NATIONAL FLOOD INSURANCE PROGRAM

Case No.: 22-06-2510P
Community: City of Albuquerque, and
Bernalillo County, New Mexico
Community No.: 350002 and 350001

Identifier:	Juan Tabo Hills
Flooding Source:	Tijeras Arroyo
FIRM Panel(s) Affected:	35001C0366H and 35001C0367H

Summary of Additional Data Required to Support a Letter of Map Revision (LOMR)

PROJECT Juan Tabo Hills West
SUBJECT Section 8
BY JRH DATE 12-17-13
CHECKED _____ DATE _____
SHEET _____ OF _____

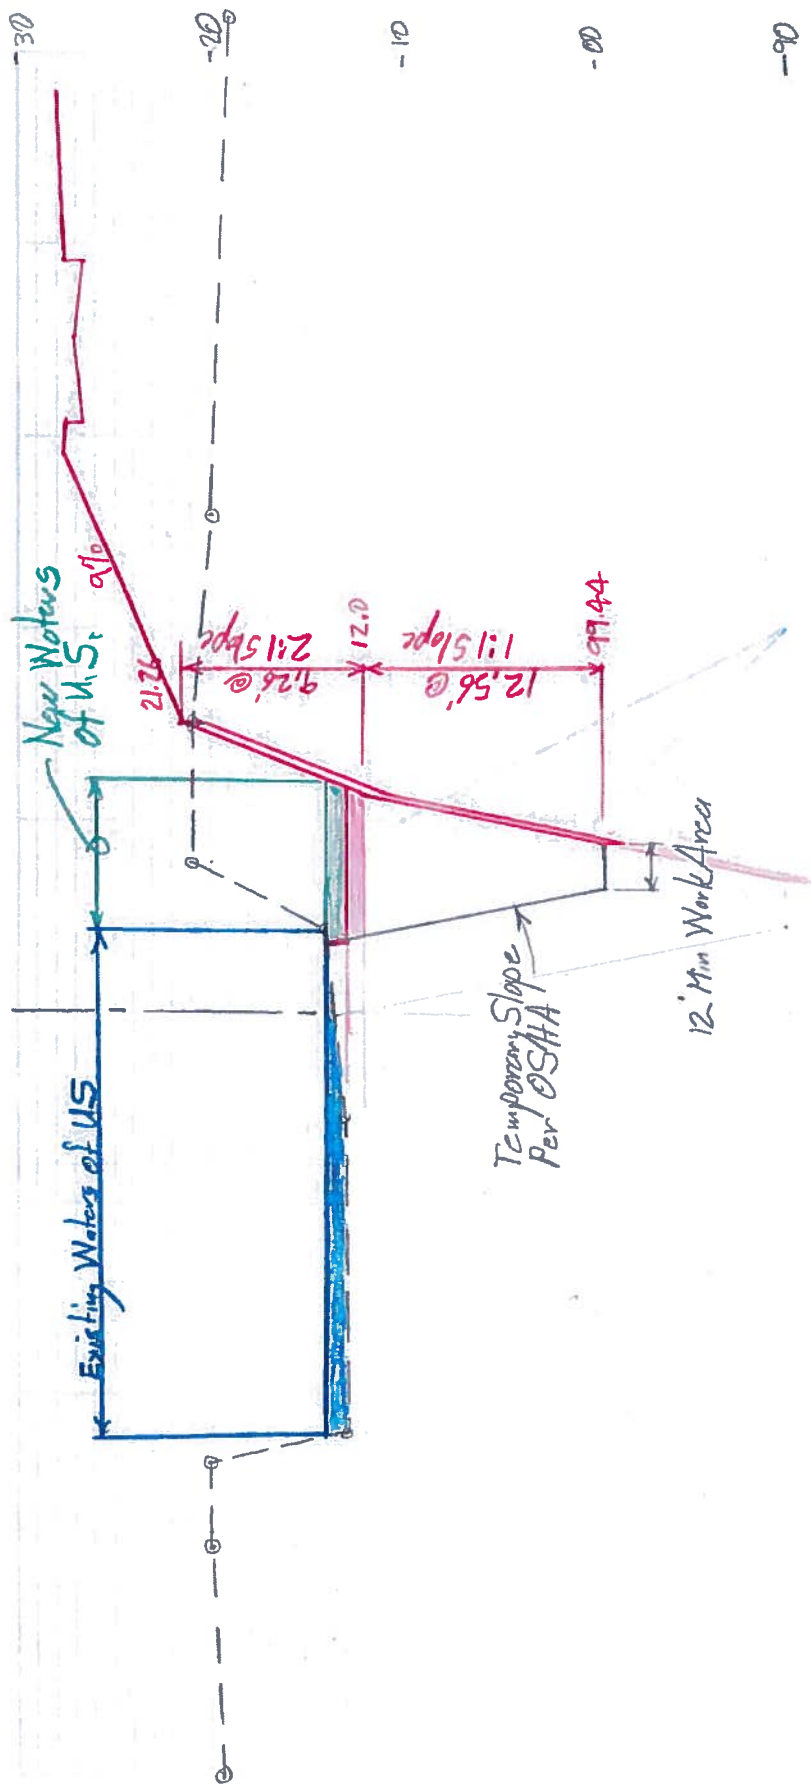
2. Our review revealed that the right overbank cross section endpoint is below the 0.2-percent-annual-chance floodplain elevation at Cross Section 8. The use of vertically extended cross sections might both overestimate the floodplain elevation and underestimate the width of the floodplain. Please revise the cross section geometry coordinates so that the end points of all cross sections are equal to or extend higher than the corresponding floodplain elevations.
